Our ref: SSD 8970

**Physical Education Precinct for St Joseph's College (SSD 8970)
Mark Street, Hunters Hill – Response to Submissions**

23/11/2018

LANDSCAPE TO NEW SPORT HALL

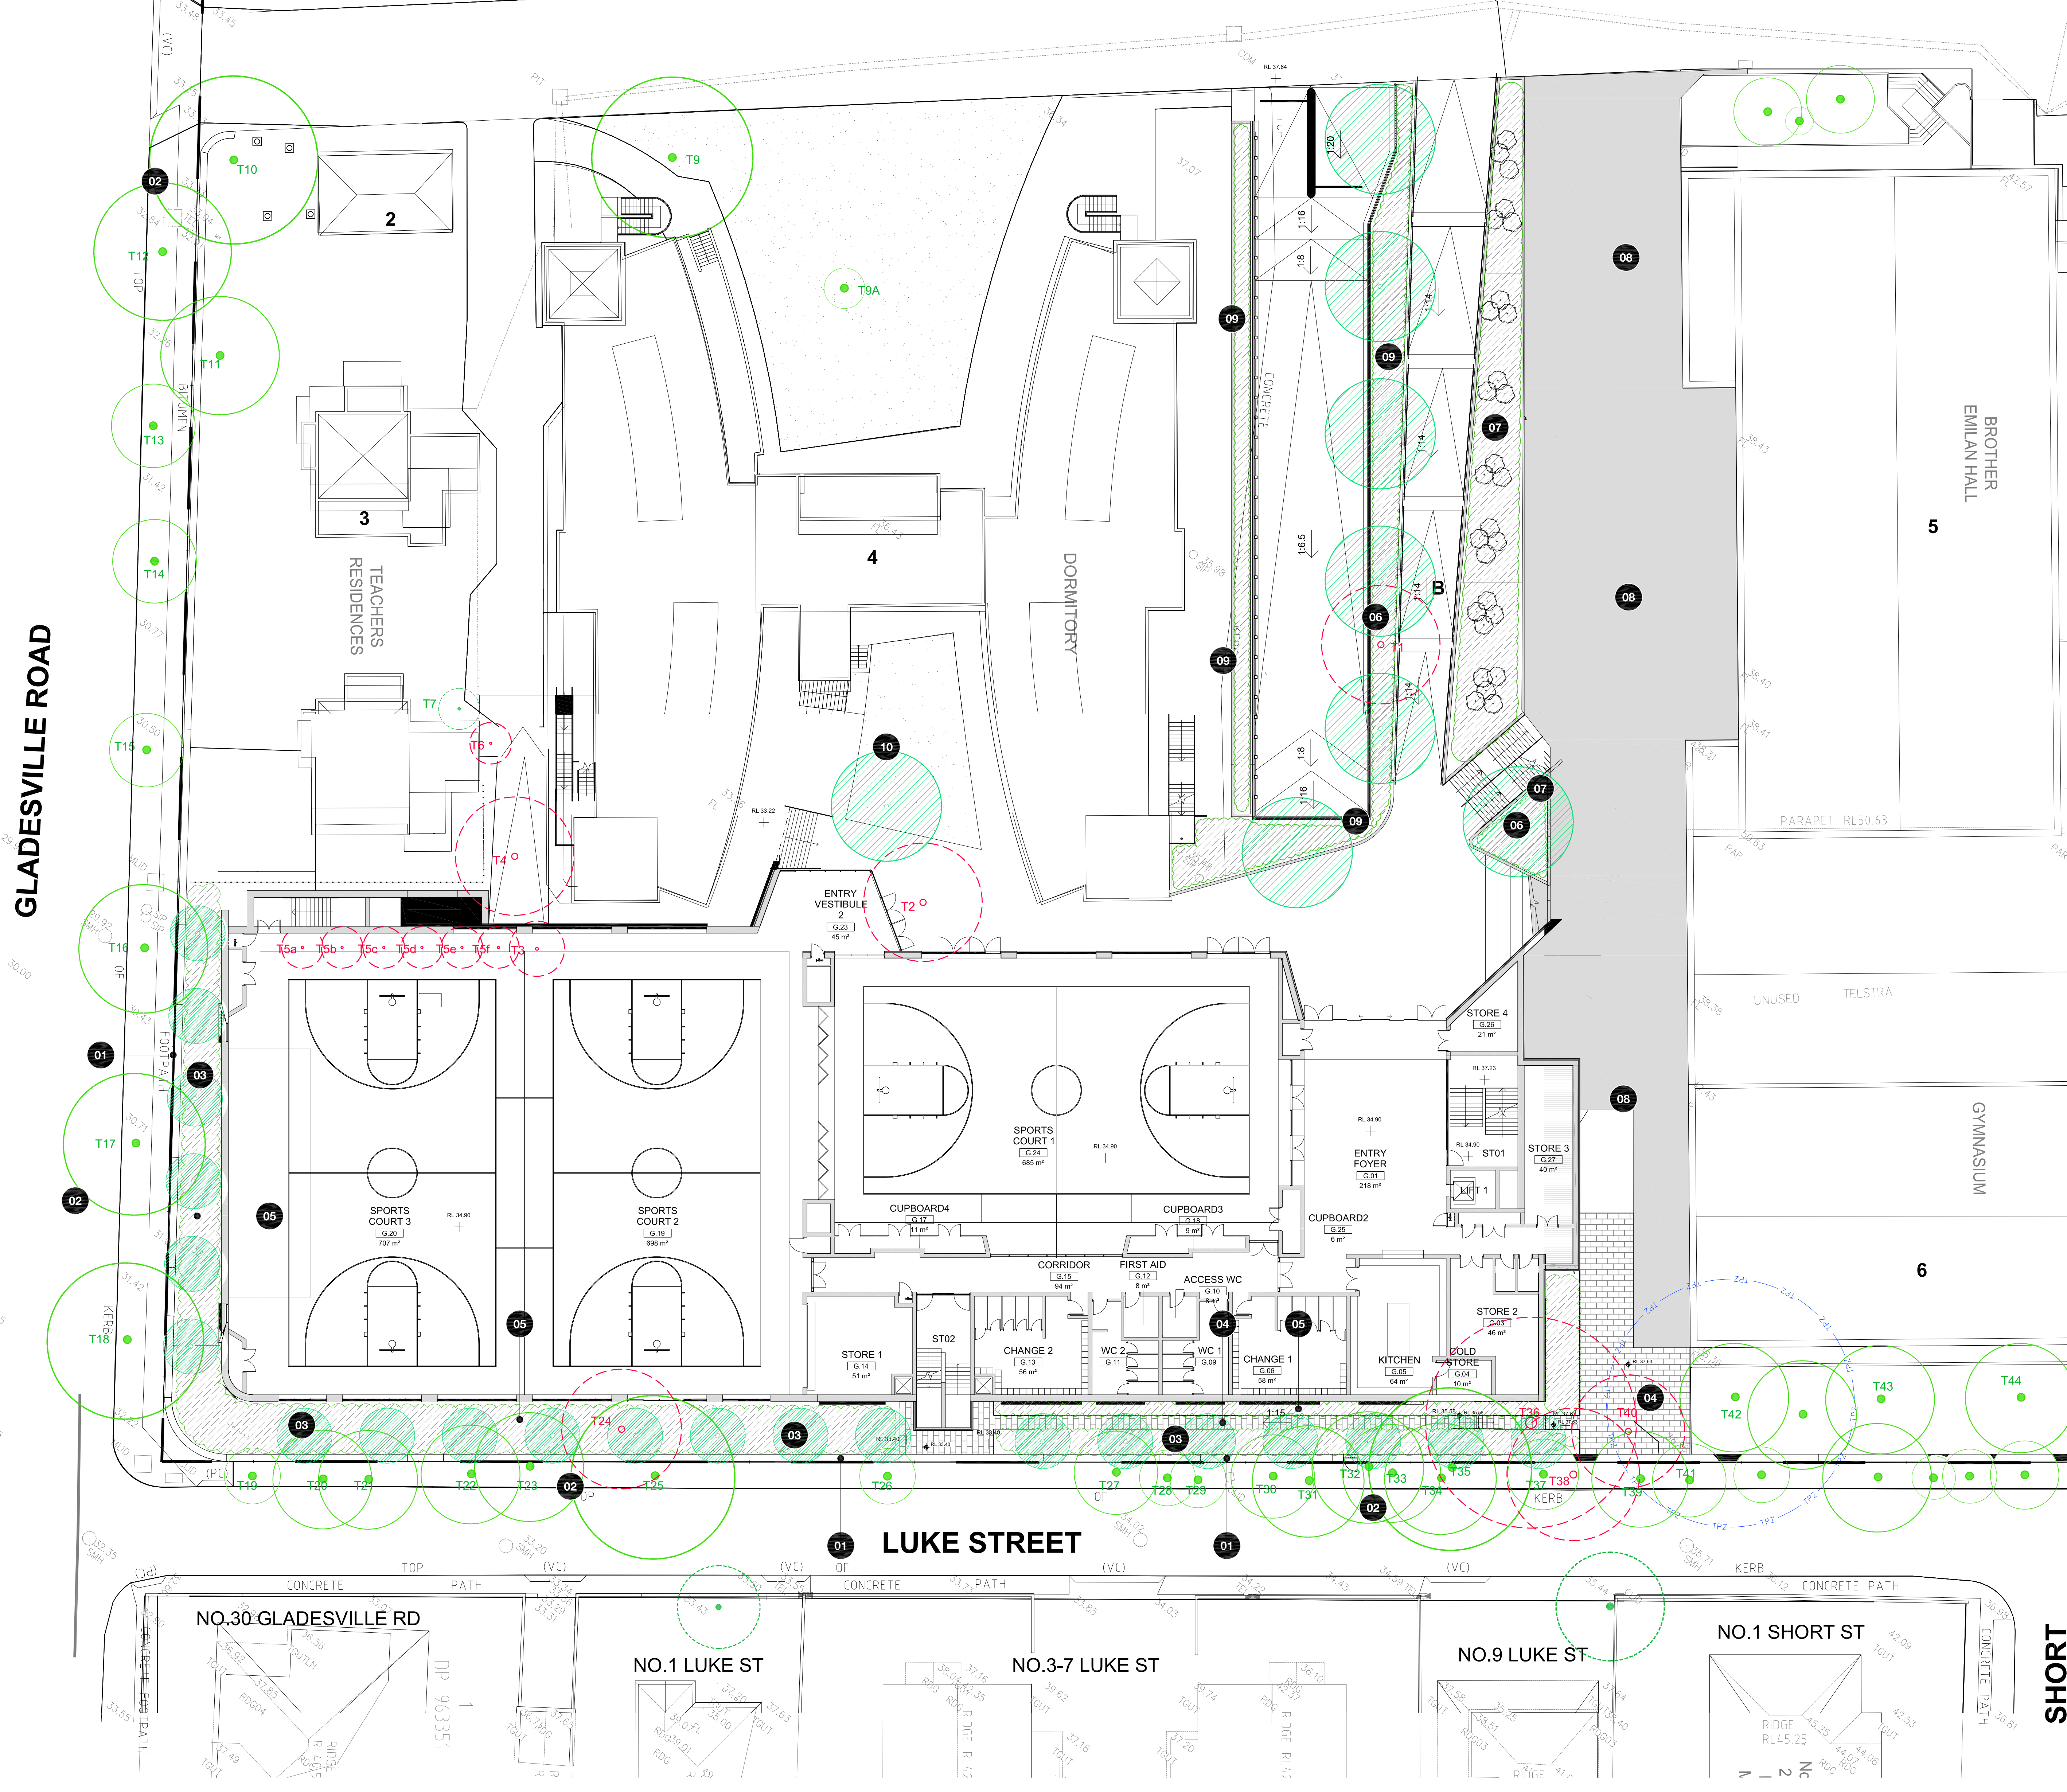
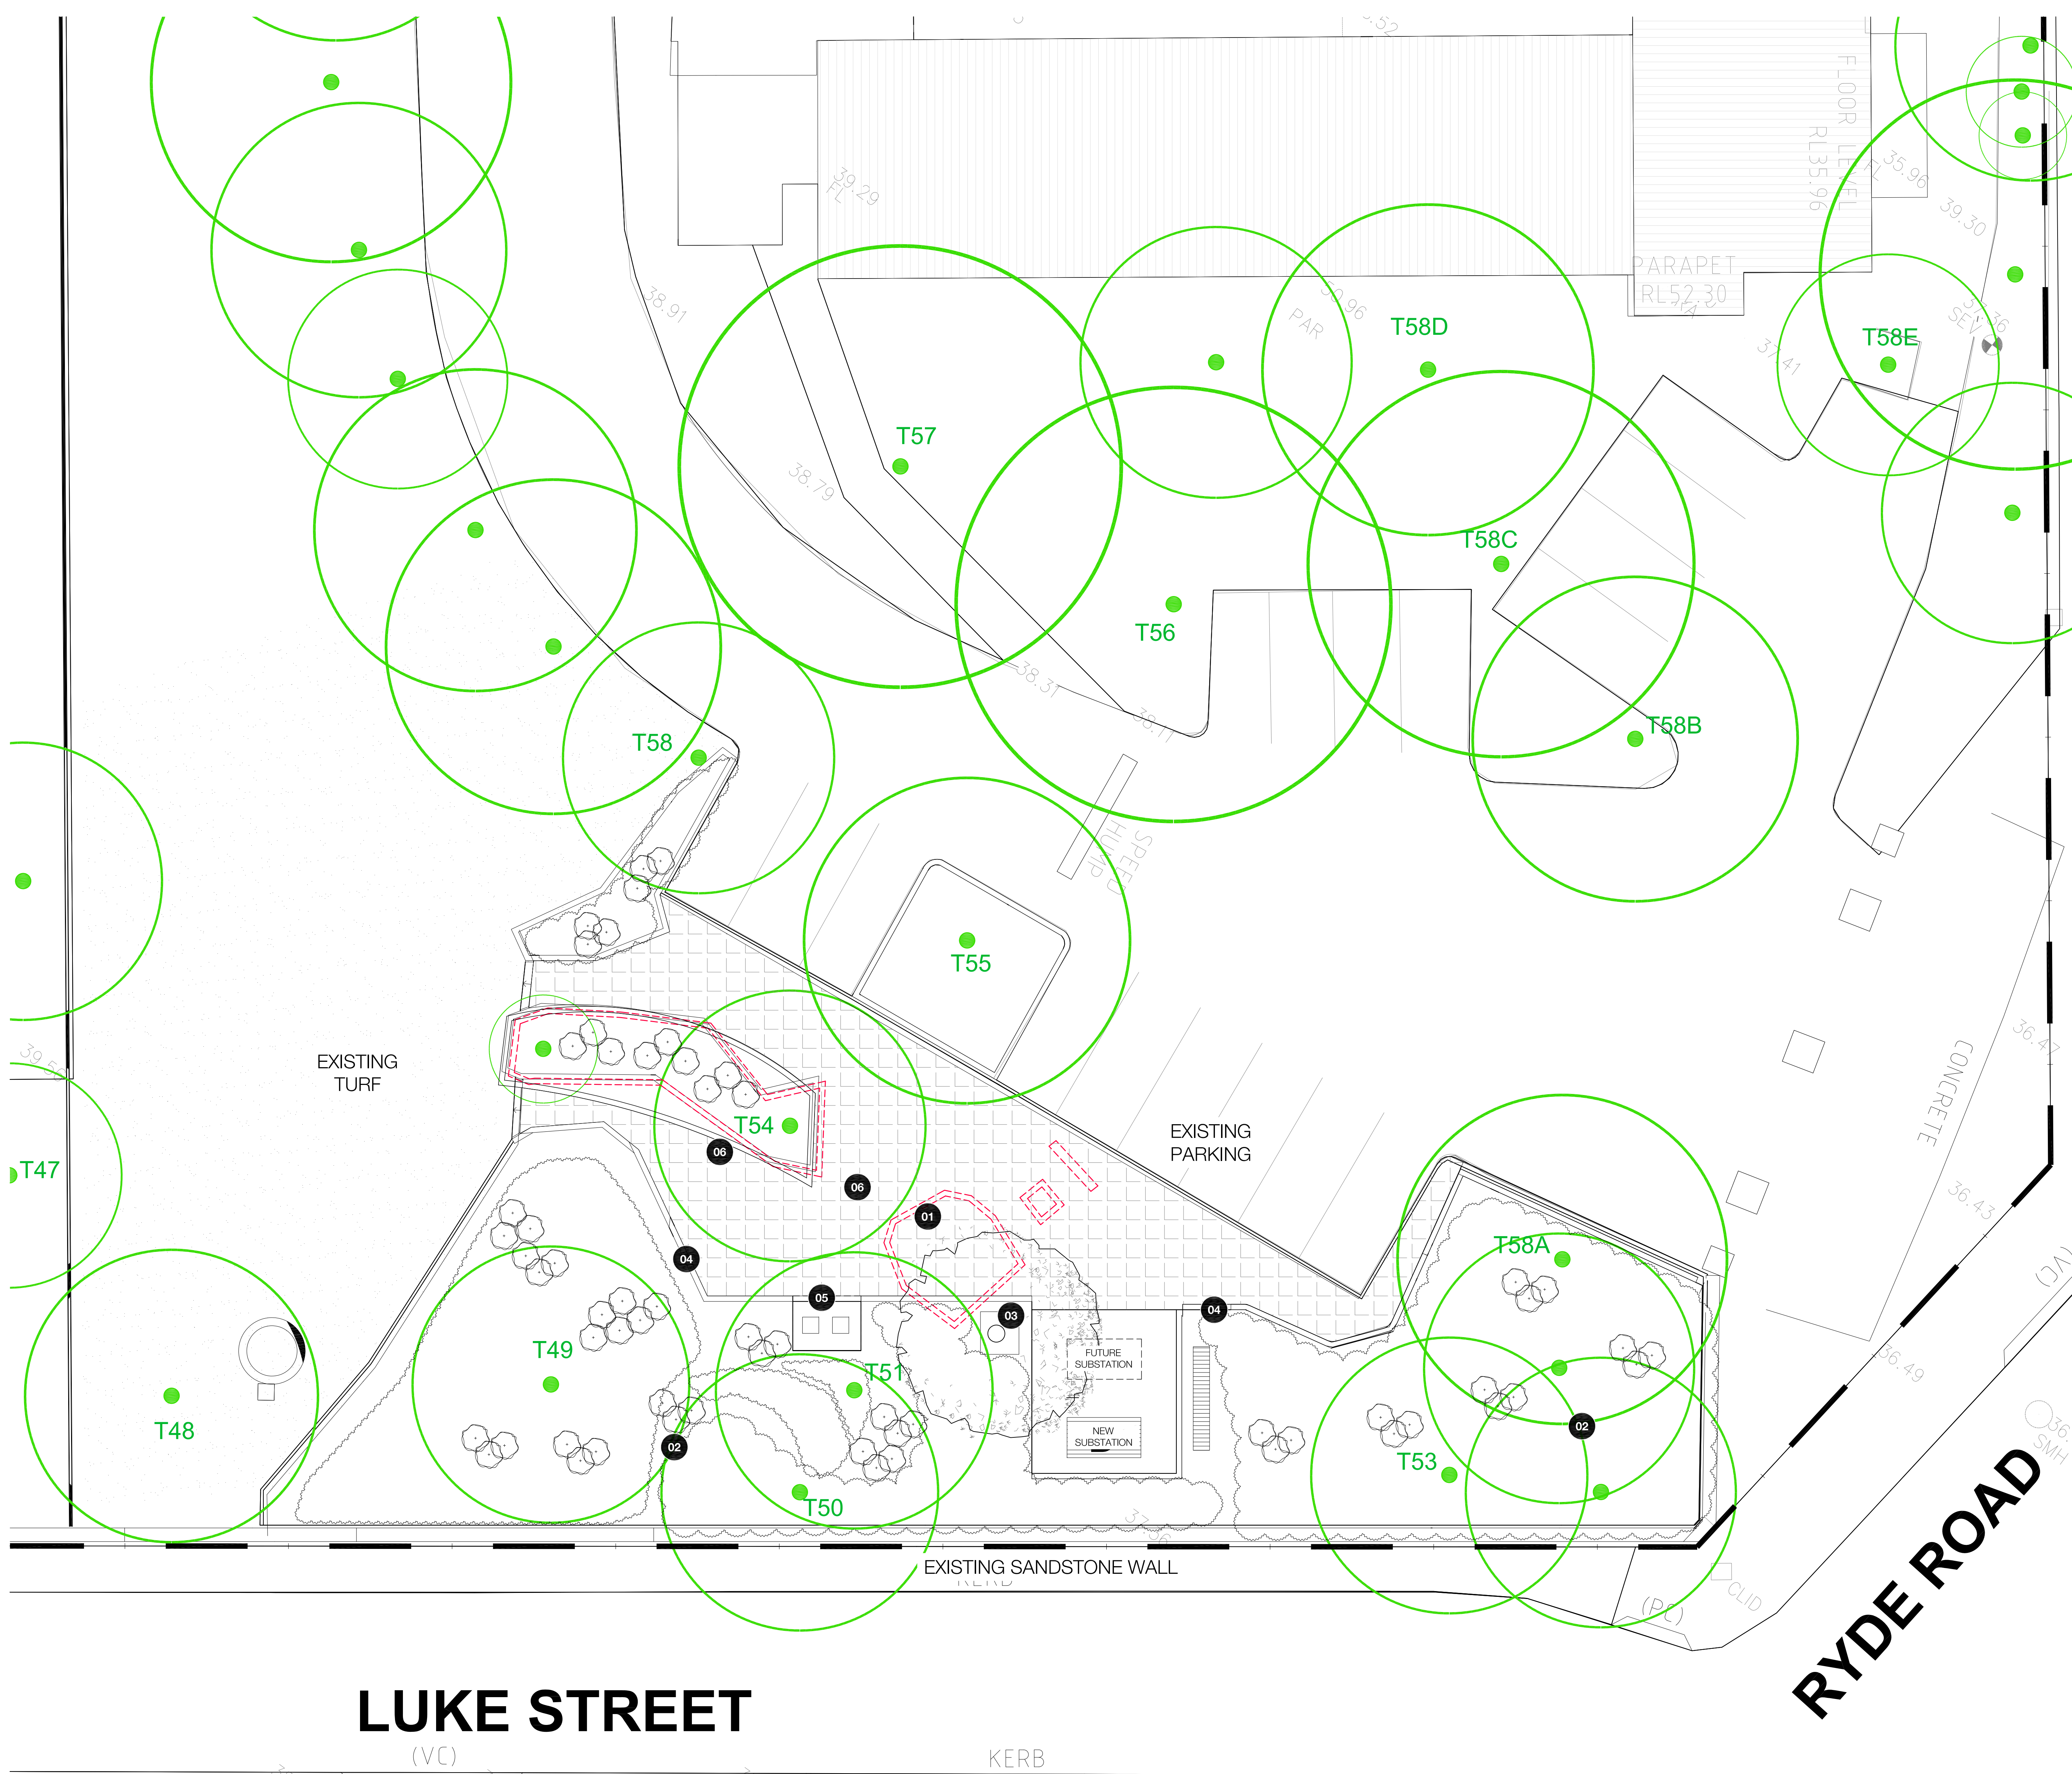
- The submitted plans do not identify the total number of individual trees that are proposed to be removed within the site and outside the boundary of the site. The Department notes that one row of trees has been counted as a single tree, which is not acceptable. Each tree should be individually identified, and the impacts of removal assessed.

- The Department considers that additional replacement tree planting should be provided within the site, especially along the peripheries (front setback areas), to assist with screening the building and offsetting the loss of tree canopy within the site including six large trees.

- The Department requires that a comprehensive schedule of the total number of trees that are proposed to replace the loss of tree canopy be submitted. The proposed replacement planting should comprise of native species ranging in height from 14 to 30 metres.

- Updated landscape plans must be submitted including details of the replacement planting within the site.
